WEST SUSSEX COUNTY COUNCIL CONSULTATION

TO:	Arun District Council FAO: Simon Davis
FROM:	Highways, WSCC
DATE:	19/09/2018
LOCATION:	A The Paddock, 34 Northfields Lane, Aldingbourne, Chichester, PO20 3UH
SUBJECT:	AL/79/18/PL 1 No. bungalow with 3 bedrooms in the roof (replacing permitted application AL/79/17/CLE).
DATE OF SITE VISIT:	N/A
RECOMMENDATION:	☒ Advice ☐ Objection ☐ Modification ☐ No Objection ☐ More Information ☐ Refusal
S106 CONTRIBUTION TOTAL:	£N/A

SITE PLAN

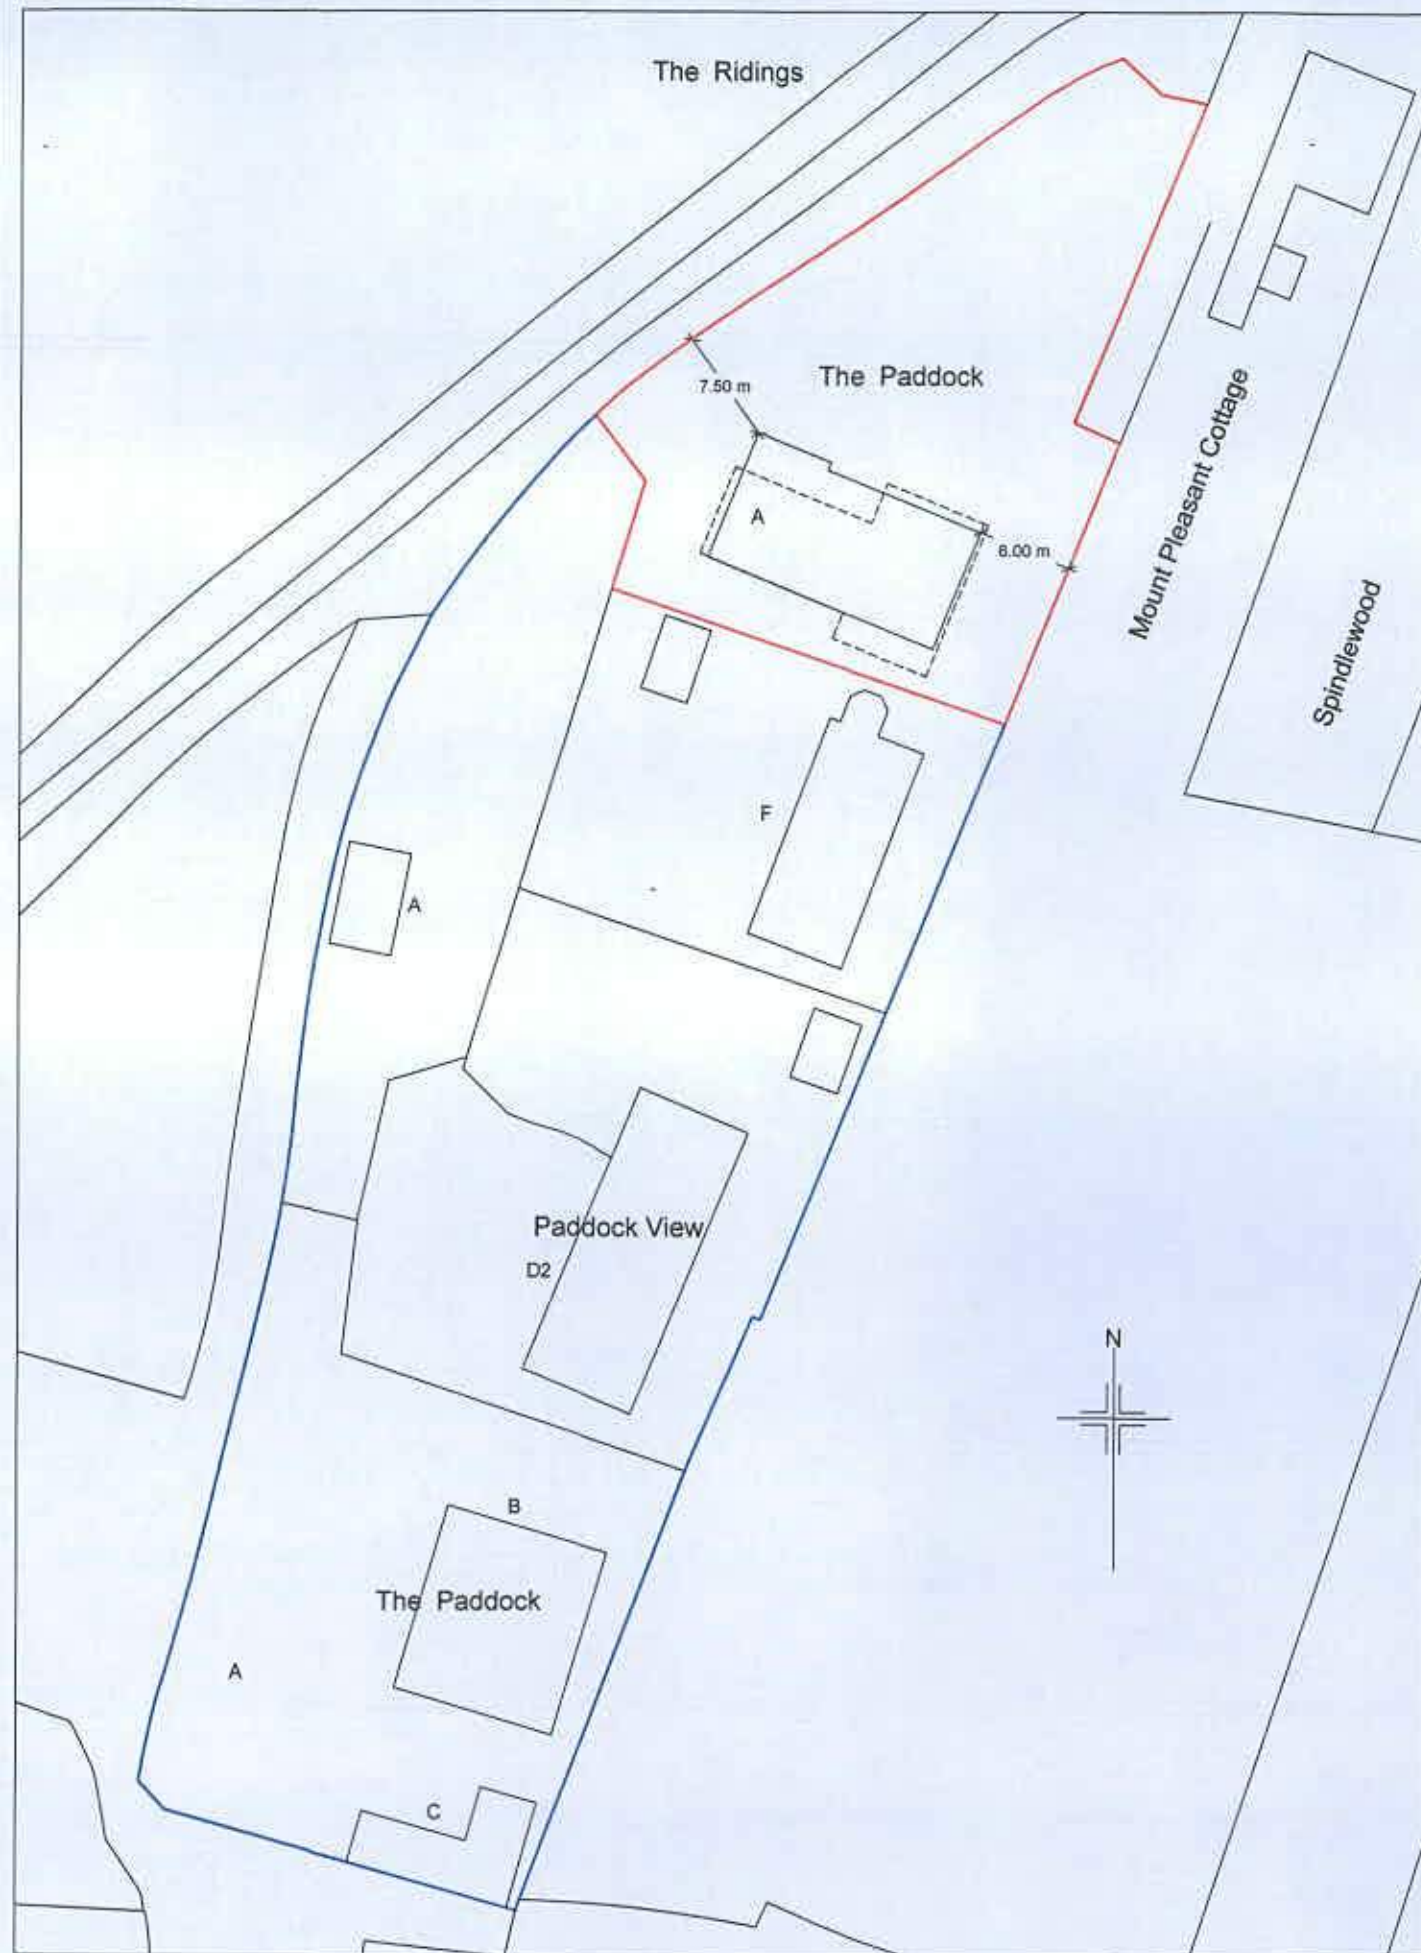
The application form indicates that three parking spaces will be provided on site although the site plan does not demonstrate parking layout. Each parking space should meet minimum specifications of 2.4 x 4.8m as set out in Manual for Streets (MfS). Details of parking can be secured via condition.

No part of the development shall be first occupied until the car parking spaces have been constructed in accordance with plans and details to be submitted to and approved in writing by the Local Planning Authority. These spaces shall thereafter be retained at all times for their designated use.
